DRAINAGE LETTER REPORT

**LOT 23, RED ROCK RESERVE
4619 REDSTONE RIDGE ROAD
MONUMENT, CO 80132**

**JPS Project No. 022603
PCD File No.: VR26[5](#)**

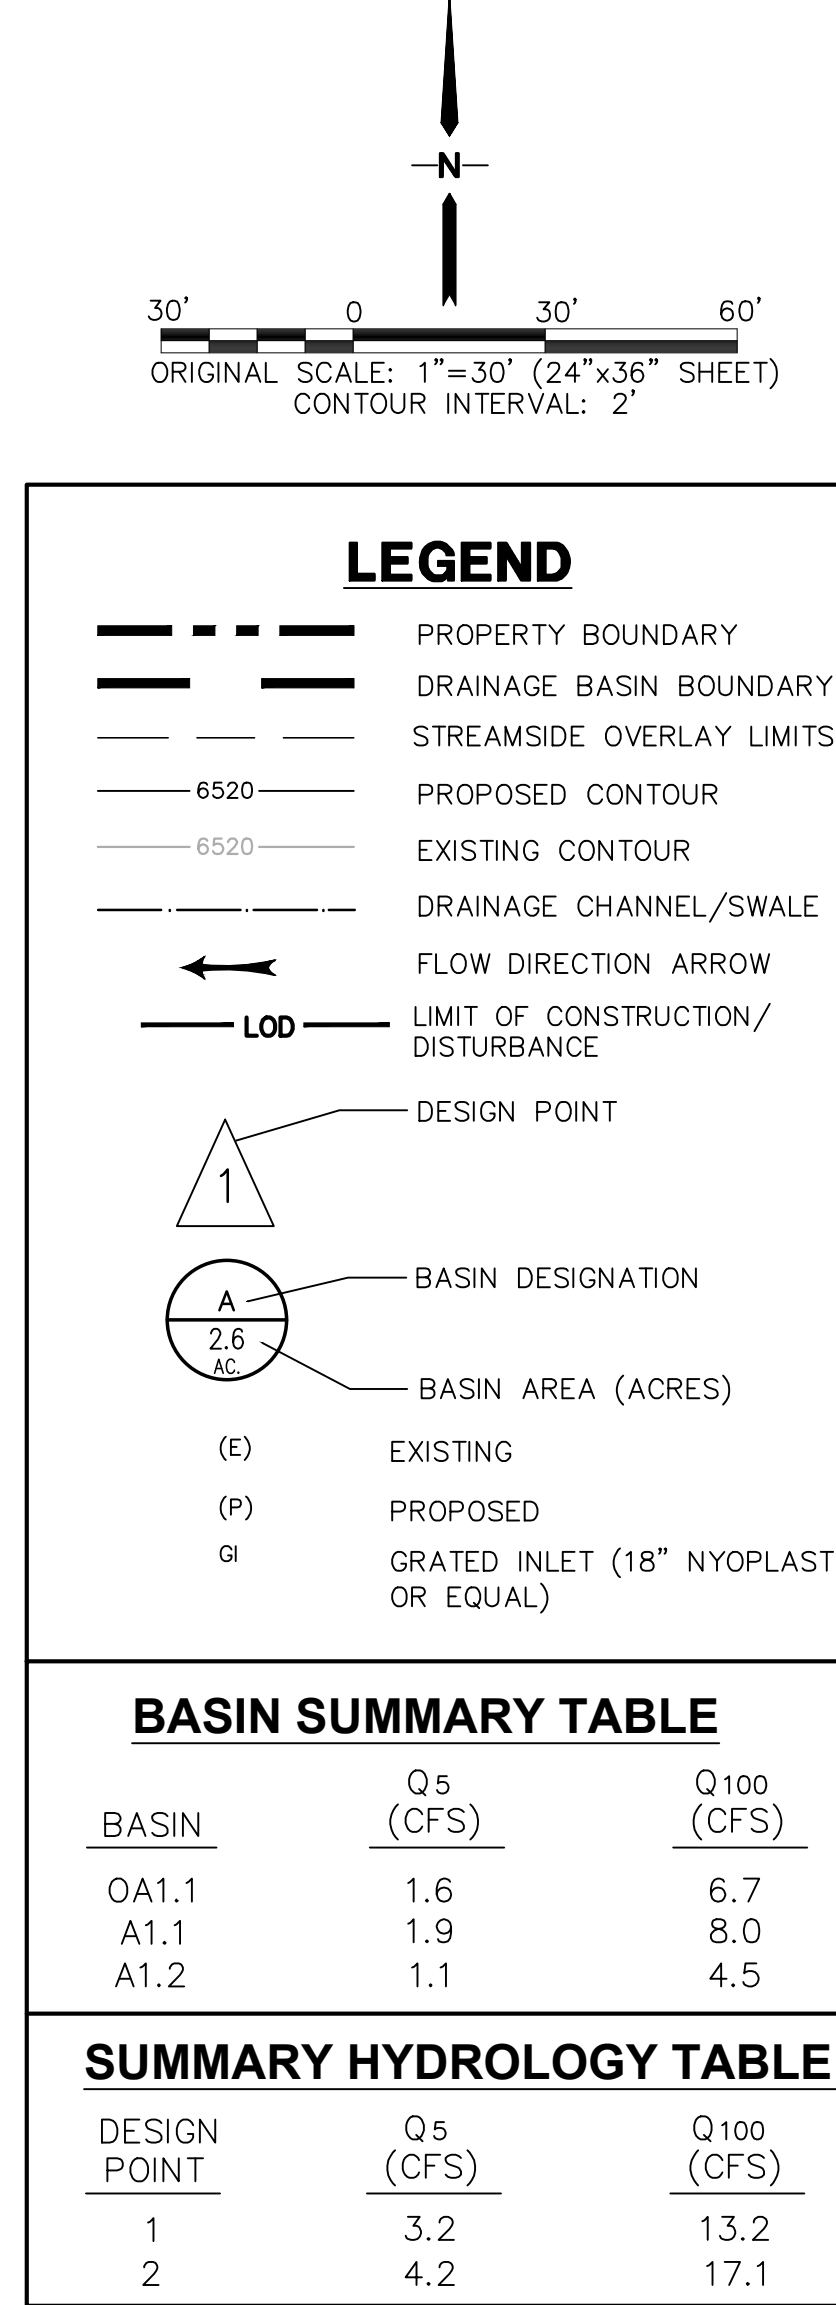
Flow is supercritical, please revise design. Grass lined swale with ECB lining is insufficient.

Flow is supercritical, please revise design. Grass lined swale with ECB lining is insufficient.
